From: Bernadette Owens
Sent: 07 September 2021 12:49
To: DC Support
Subject: FW: Planning notification for application reference: 21/02467/F

I am commenting on the above application from an arboricultural aspect.

Proposal – to build a hotel, offices and other facilities with landscaping

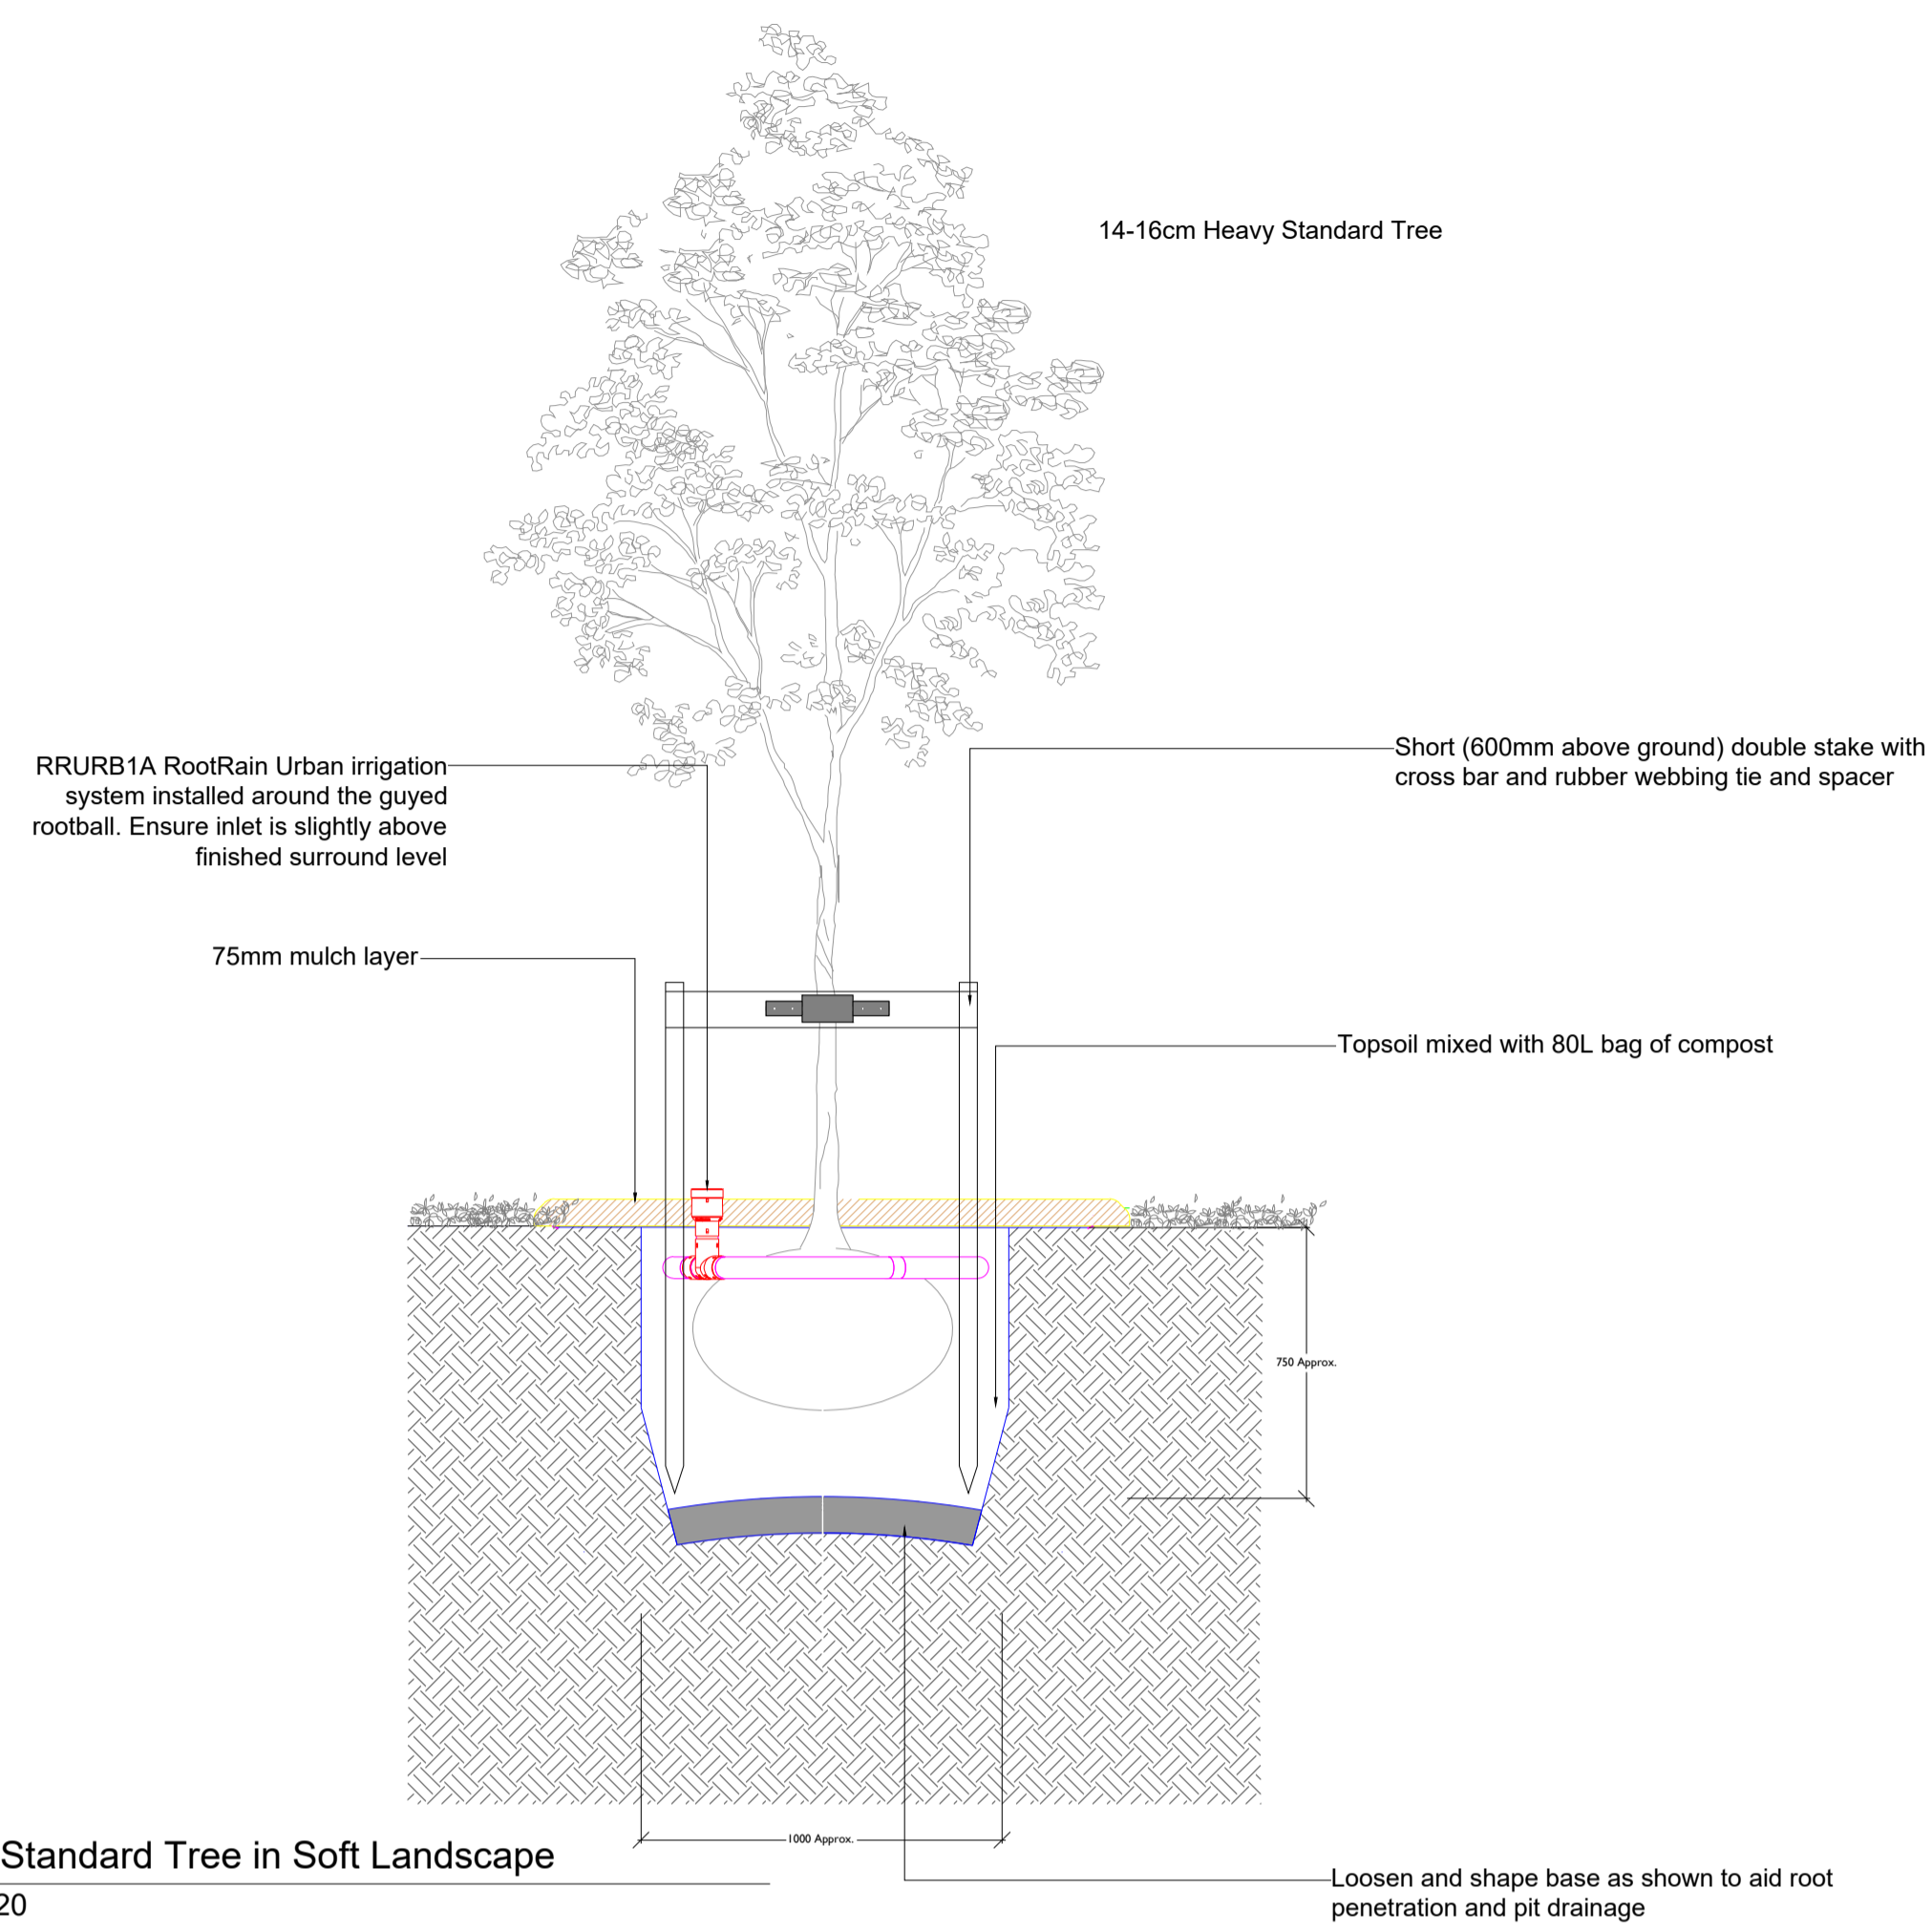
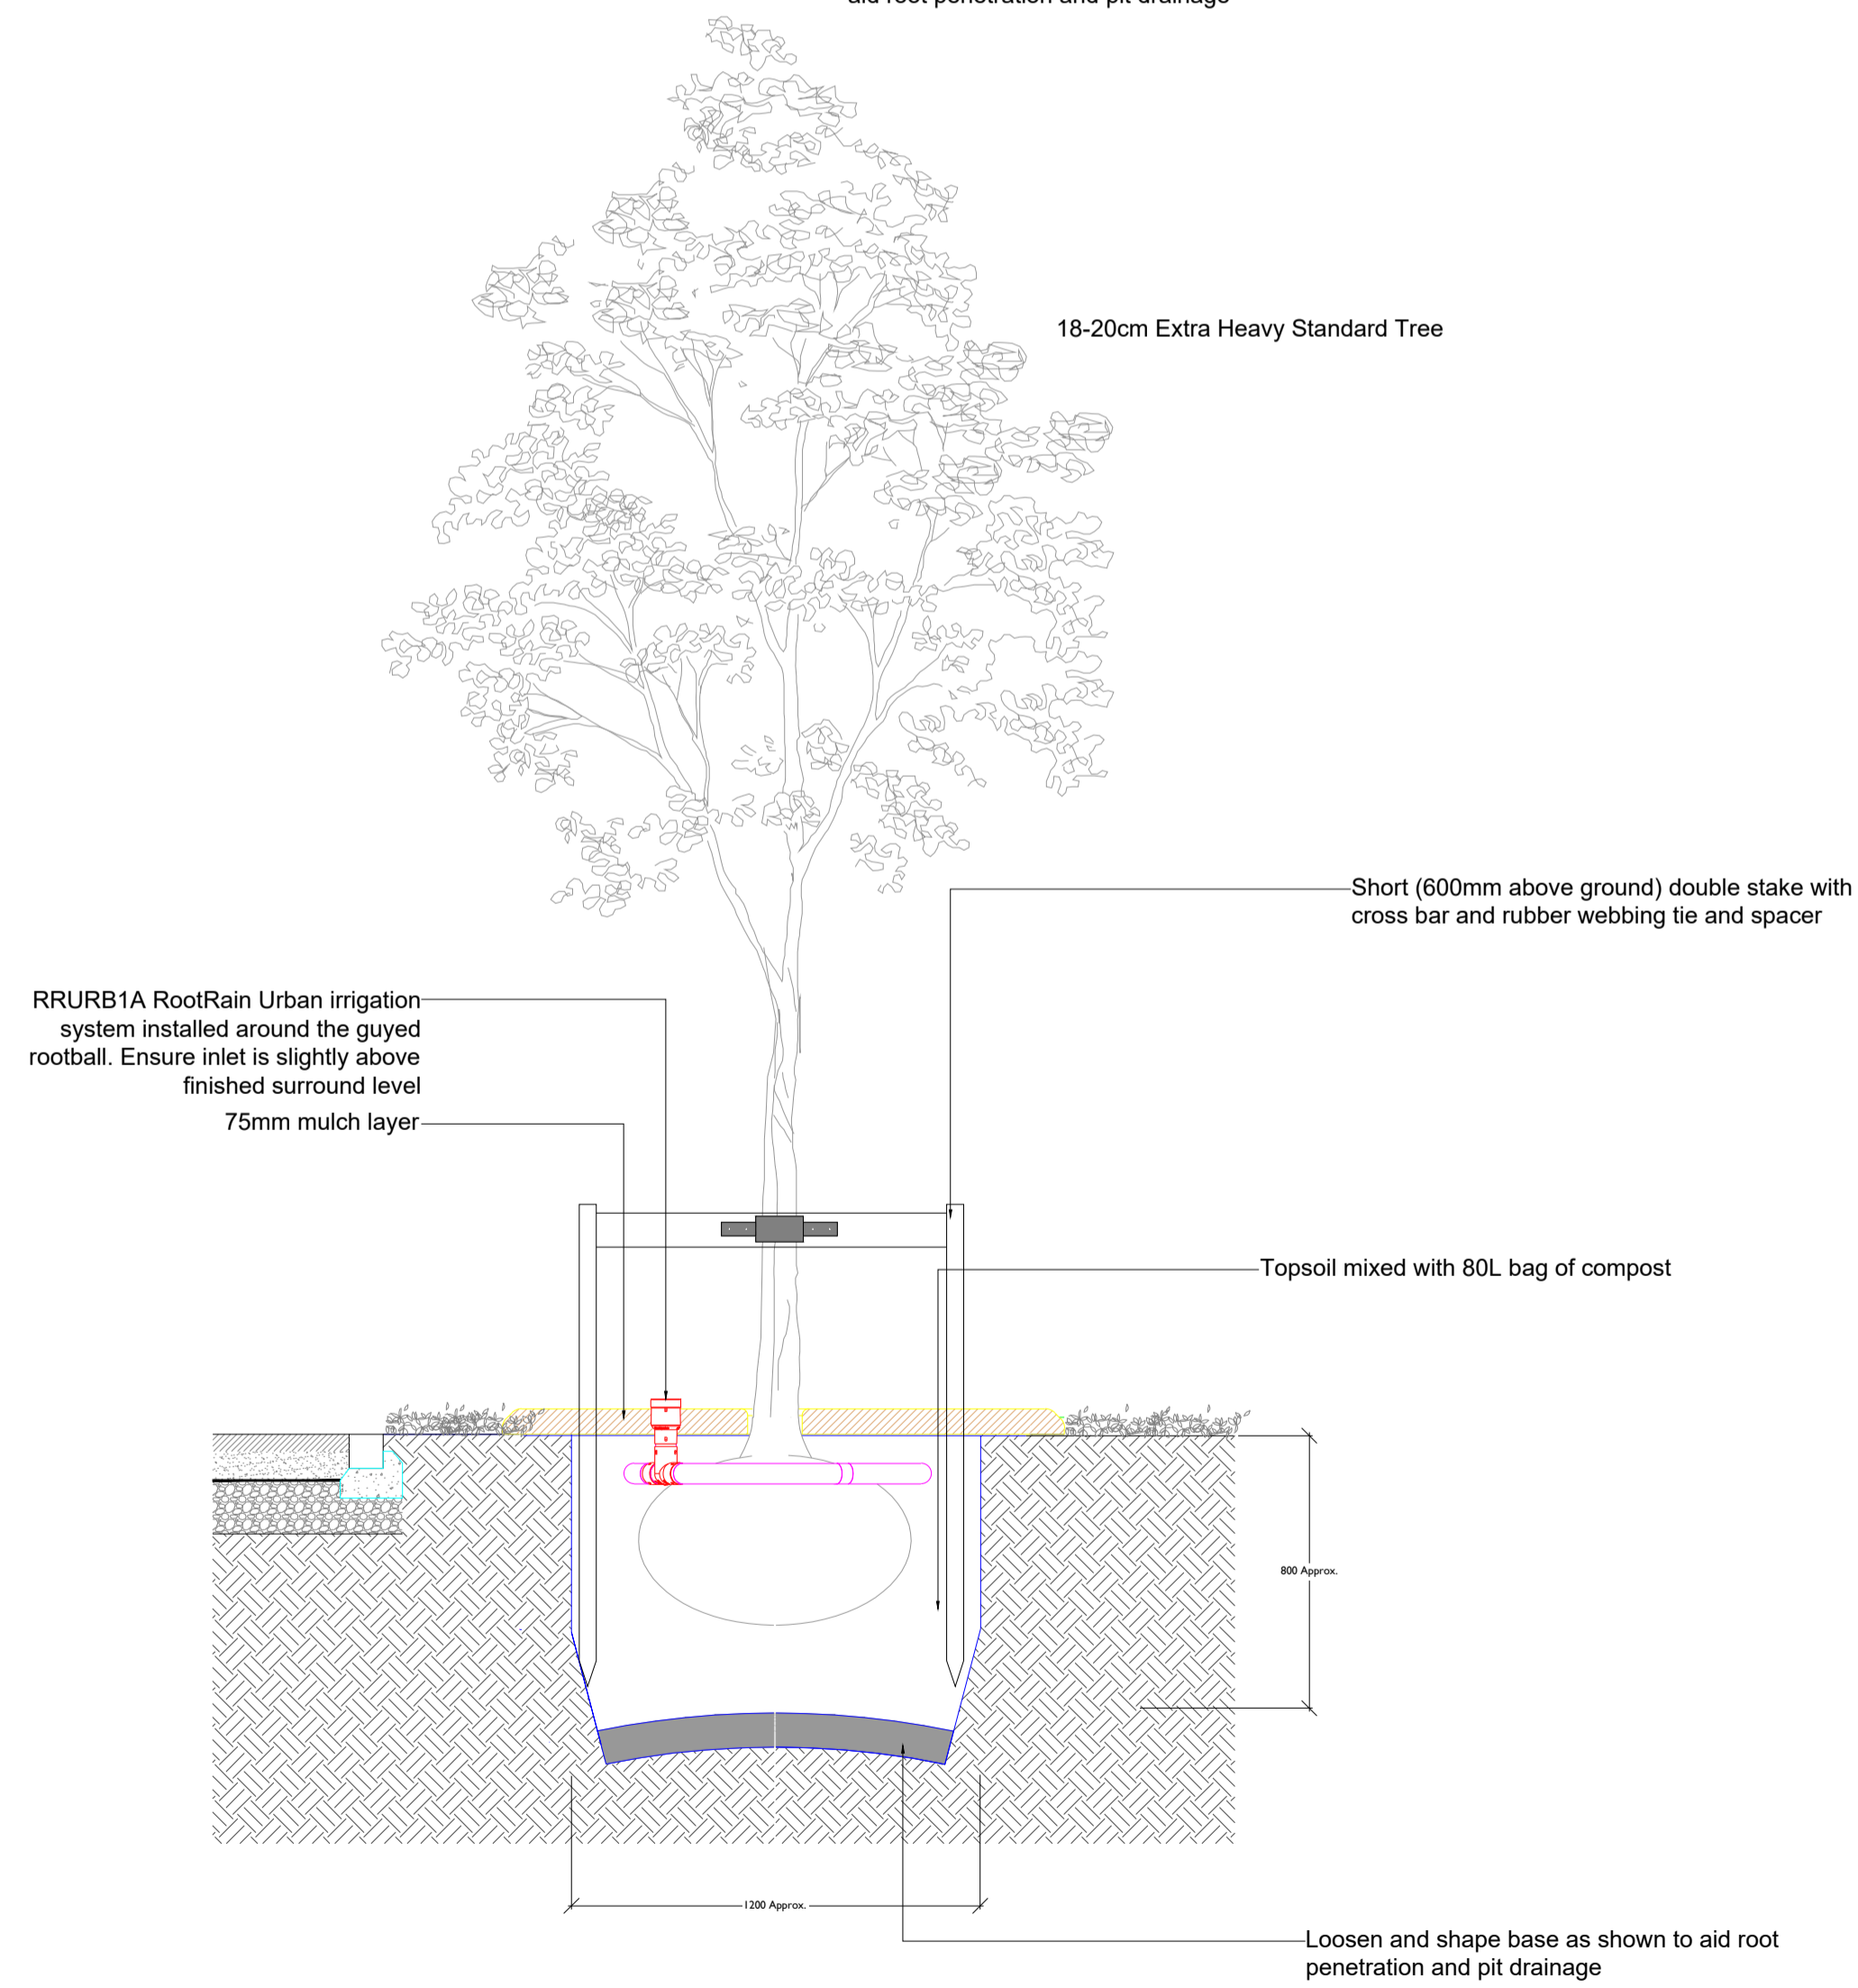
1. The submitted arboricultural report and method statement does not relate to this proposed layout so an updated report is required.
2. The landscape detail plan does not have a tree pit design.
3. The maintenance schedule requires more detail and cover a 2 year period to establishment.
4. All the trees should be 12-14 cm size to ensure a more established landscape.
